Re - Mandalong Mine Extension Modification 9 Longwall Reorientation, near Morisset, (SSD-5144) – Review of Modification Report

BCD has reviewed the '*Mandalong Mine Modification report for modification to development consent (SSD-5144)*' Modification Report (MR; prepared by EMM Consulting Pty Ltd and dated 14 May 2020), including relevant appendices, annexures and attachments in relation to impacts on biodiversity, Aboriginal cultural heritage, flooding and flood risk. BCD does not have any comments in relation to biodiversity.

Mandalong Mine Extension Modification 9 Longwall Reorientation, near Morisset, (SSD-5144) – Review of Modification Report

Figure 5 | Location of recorded Aboriginal cultural heritage sites

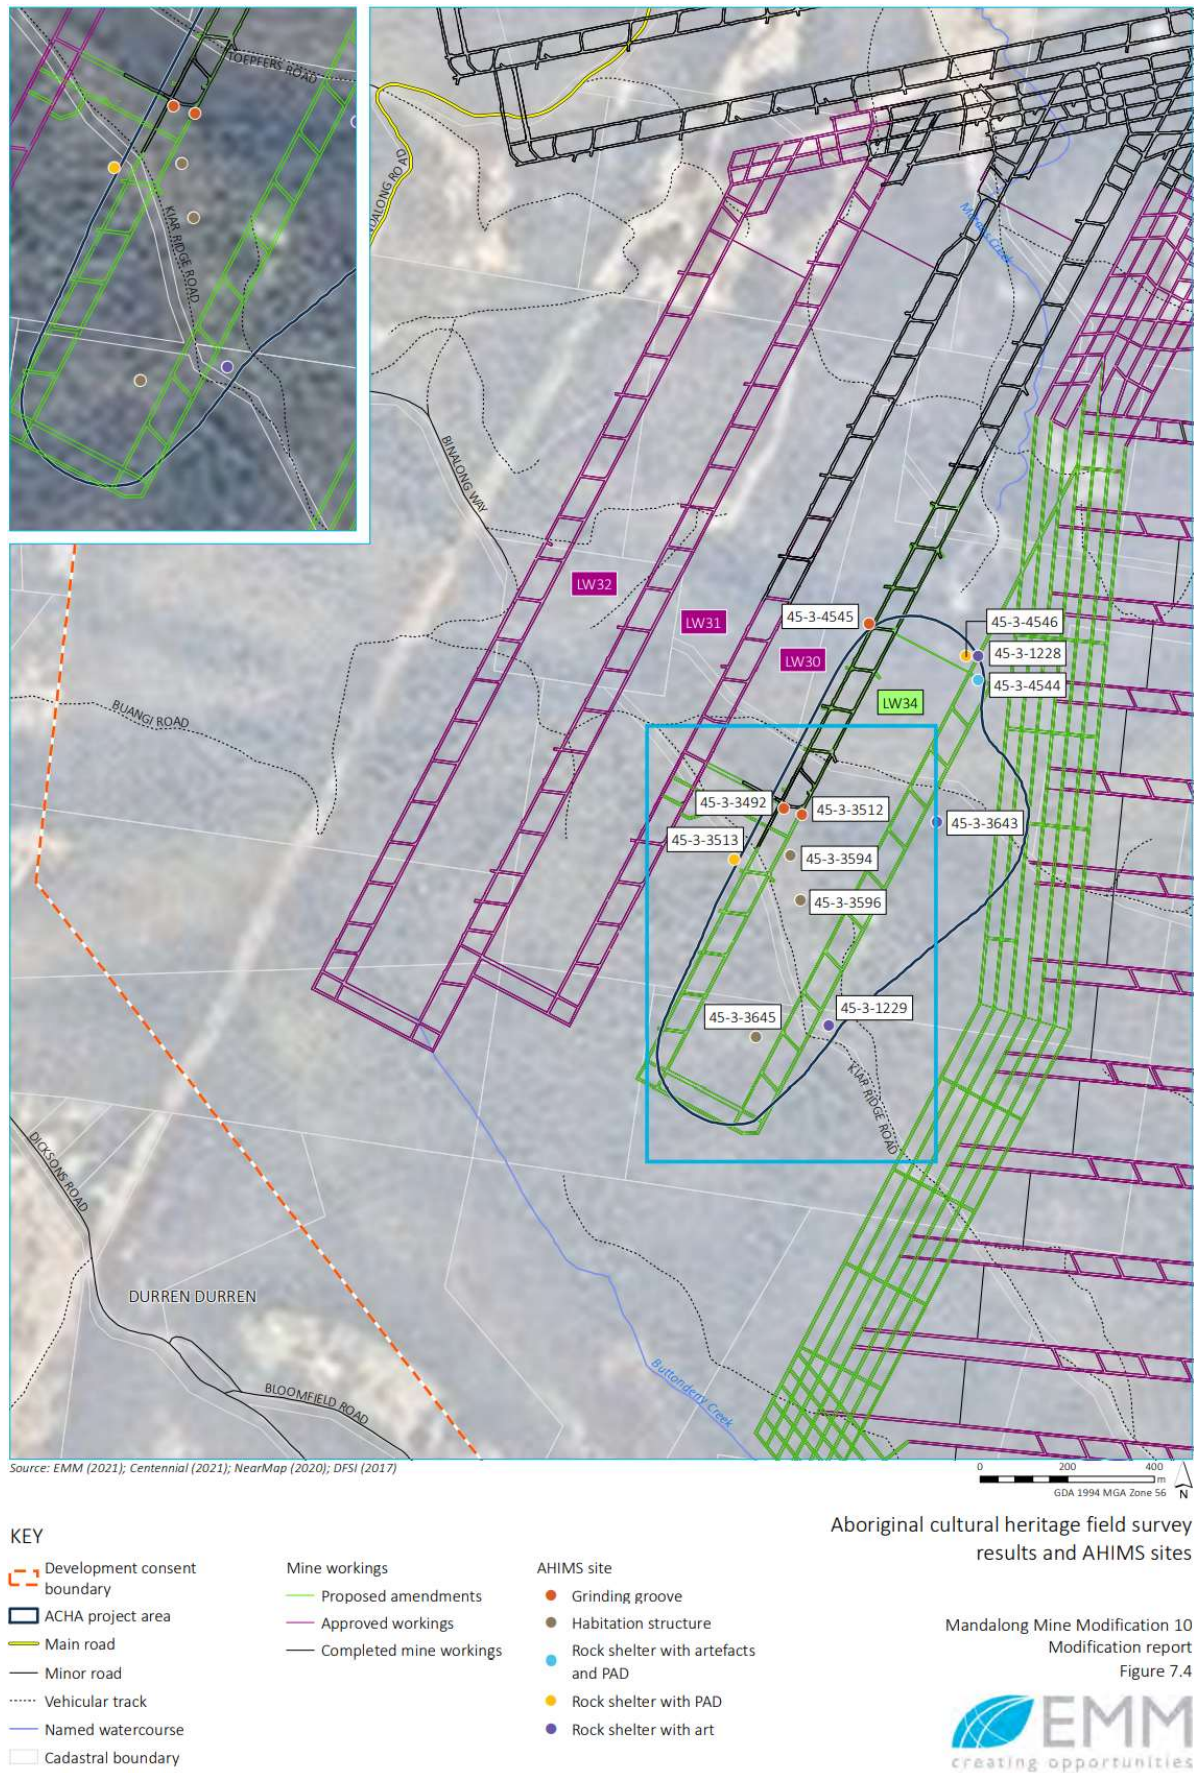
Consultation has not been undertaken with the registered Aboriginal parties (RAPs) on the increased level of predicted impacts to some Aboriginal sites from Modification 9. Initial consultation advising the RAPs that several longwalls would be reorientated and renumbered was undertaken. However, consultation has not been undertaken with the RAPs to discuss the increase in impacts to three extant Aboriginal registered sites (AHIMS 45-3-3513 Rockshelter with PAD, AHIMS 45-3-1223 Artefact Scatter and AHIMS 45-3-1226 Grinding Groove sites).

Modification 9 includes reorientation of several of the approved longwalls LW30 – LW37 at Mandalong Mine to avoid the effects of a geological fault. These longwalls have been renumbered to LW30 – LW34. Ditton Geotechnical Services Pty Ltd (DGS 2020) predict an increase in impacts to three previously recorded and currently extant Aboriginal sites. The predicted increase in impacts to the three sites are:

- AHIMS 45-3-3513 Rockshelter with PAD LW30 – increase from Possible to Likely
- AHIMS 45-3-1223 Artefact Scatter LW30 – increase from Possible to Likely
- AHIMS 45-3-1226 Grinding Groove LW31 – increase from Very Unlikely to Possible

The approved Aboriginal Cultural Heritage Management Plan has not been updated to include the impacts of Modification 9. The approved Aboriginal Cultural Heritage Management Plan should be updated to include management and mitigation measures for the three Aboriginal sites (AHIMS 45-3-3513, AHIMS 45-3-1223 and AHIMS 45-3-1226) where increased impacts are likely to occur from Modification 9.

AHIMS 45-3-3513 Rockshelter with PAD may require test excavation of the PAD to identify the nature and extent of the PAD to mitigate against the predict likely impact to the site from the effects of subsidence.

AHIMS 45-3-1223 Artefact Scatter may require salvage of the Aboriginal objects to mitigate against the predict likely impact to site from the effects of subsidence.

AHIMS 45-3-1226 Grinding Grooves are expected to be directly impacted by the proposed Modification.

Baseline recording and site monitoring should be undertaken for the three sites.

Consultation should be undertaken with the registered Aboriginal parties regarding the increase in the impacts to three Aboriginal sites and to inform the development of proposed mitigation and management measures from the predicted impacts of Modification 9.

BCD recommends that the approved Aboriginal Cultural Heritage Management Plan should be updated to include management and mitigation measures for the three Aboriginal sites (AHIMS 45-3-3513, AHIMS 45-3-1223 and AHIMS 45-3-1226) where increased impacts are likely to occur from Modification 9.
